Please treat as substitute plans and add e-mail from agent as additional info

Please see e-mail below in reply to your e-mail of last week.
The plot separation is therefore as block plan. (Attached)

Please can you advise whether the cabin would share any facilities with the main house and where car parking provision and amenity space provision for the existing dwelling and the cabin and other unit at the property are proposed to be located.

Block plan
1:500

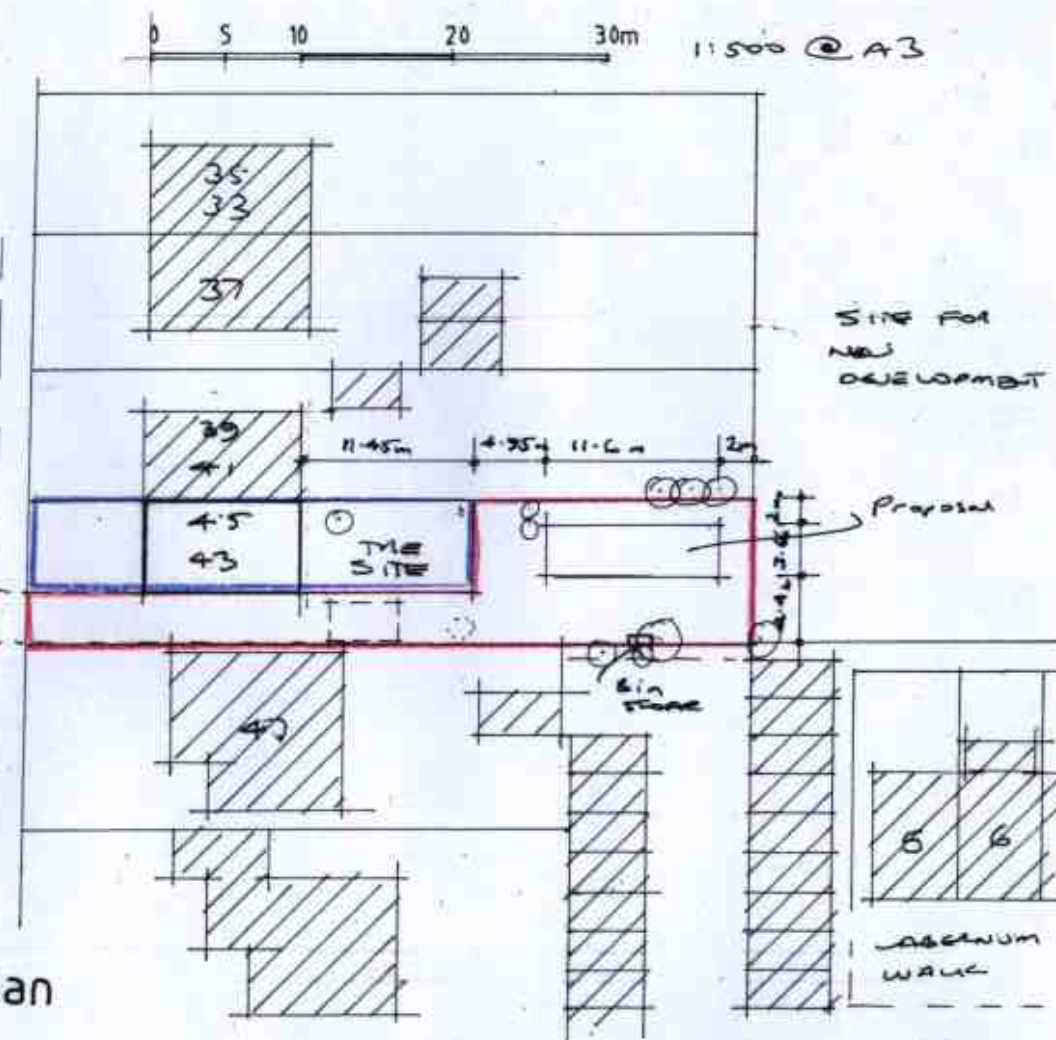
I would suggest an amended block plan is submitted to clarify .

Hi Ivan,
Thank you for your email.
The upstairs flat owns no part of the front garden, rear garden or driveway. Originally the upstairs owned the back section of the rear garden. But this was purchased from them by me it's all been registered with land registry.
Parking for downstairs flat could either be parking on road, or off-road parking to the front garden.
